# TIERRA WEST, LLC

November 15, 2023

**RE: Golf Course and Westside (Commercial Subdivision) - 10850 Golf Course Rd NW  
Erosion and Sediment Control Plan**

CMP RISER DETAIL
NTS

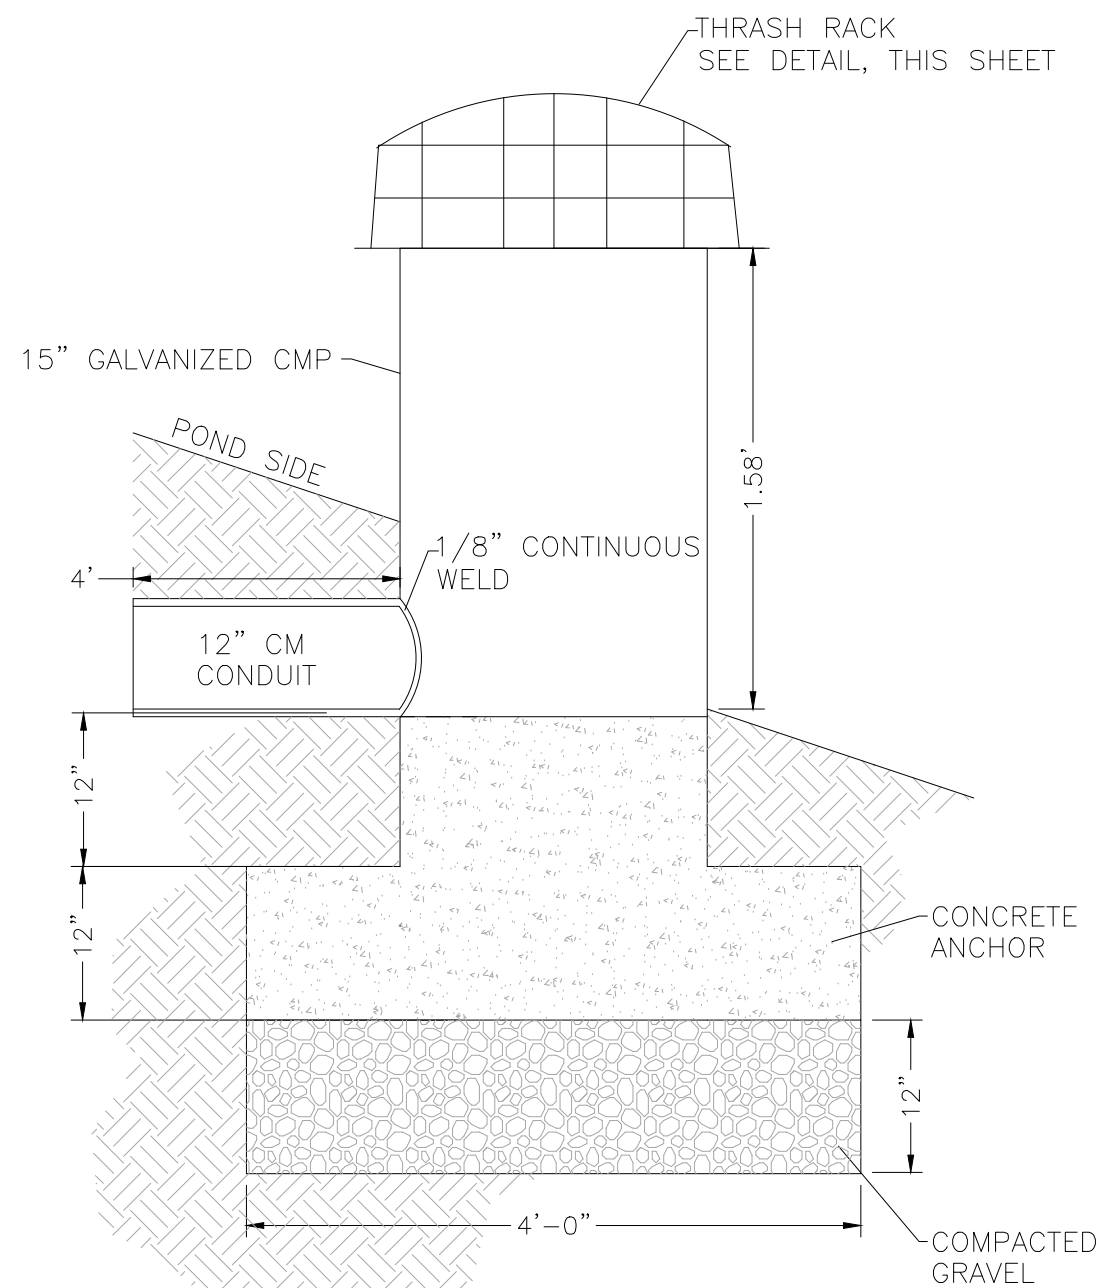
3. Identify the outlet structures that will be installed at the sediment basins per item #5 of the Construction Sequence and provide construction details that show how the structures will withdraw water from the surface of the sediment basin or similar impoundment per CGP 2.2.12.d.

**Response: Outlet structures were identified on sheet SWP-1 and the detail is provided on sheet SWP-4 and is also detailed on the grading plan.**
4. Provide details, including specifications for construction, inspection, and maintenance of the erosion controls and velocity dissipation devices to prevent erosion at inlets and outlets of the sediment traps per CGP 2.2.12.e and CGP 9.6.1.c.i.
